**To:** Carol Morrissette, Chair, and Members of the Portland Planning Board  
**From:** Nell Donaldson, Planner  
**Date:** September 24, 2013  
**Re:** **Addendum to Planning Board Report #42-13** - 101-121 Newbury Street and 40  
Hancock Street

Following is a revised motion regarding the Level III site plan review for the Seaport Lofts at 101-121 Newbury Street. The conditions of approval have been revised to reflect additional comments from the city's Department of Public Services.

**BRICK SIDEWALK DETAIL**  
NOT TO SCALE

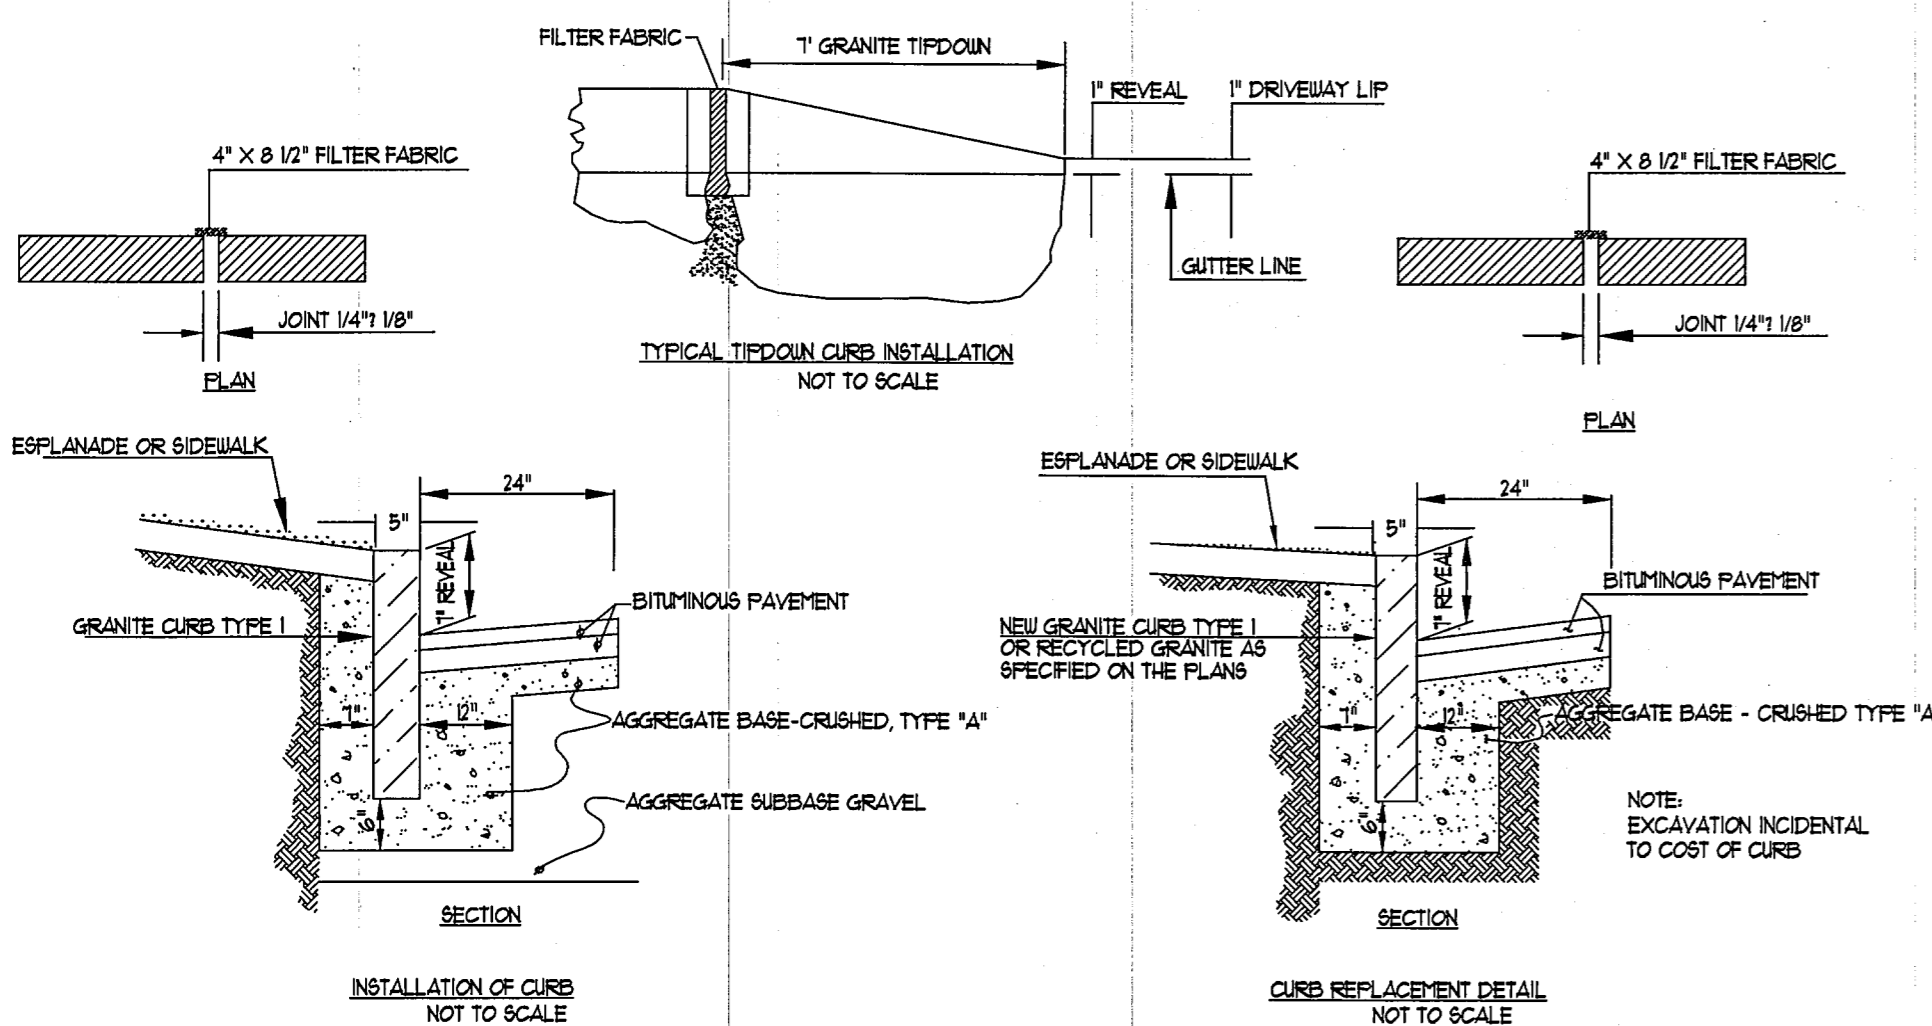
1. The applicant shall revise the final plans to include:
  - a) Delineation of the Newbury Street sidewalk in the proposed pedestrian easement area and

- b) Sidewalk running and cross slopesFor review and approval by the city's Department of Public Services;
2. The applicant shall revise the final plans to incorporate edits as requested by David Senus in his memo dated 9/18/13, for review and approval by the city's Department of Public Services;
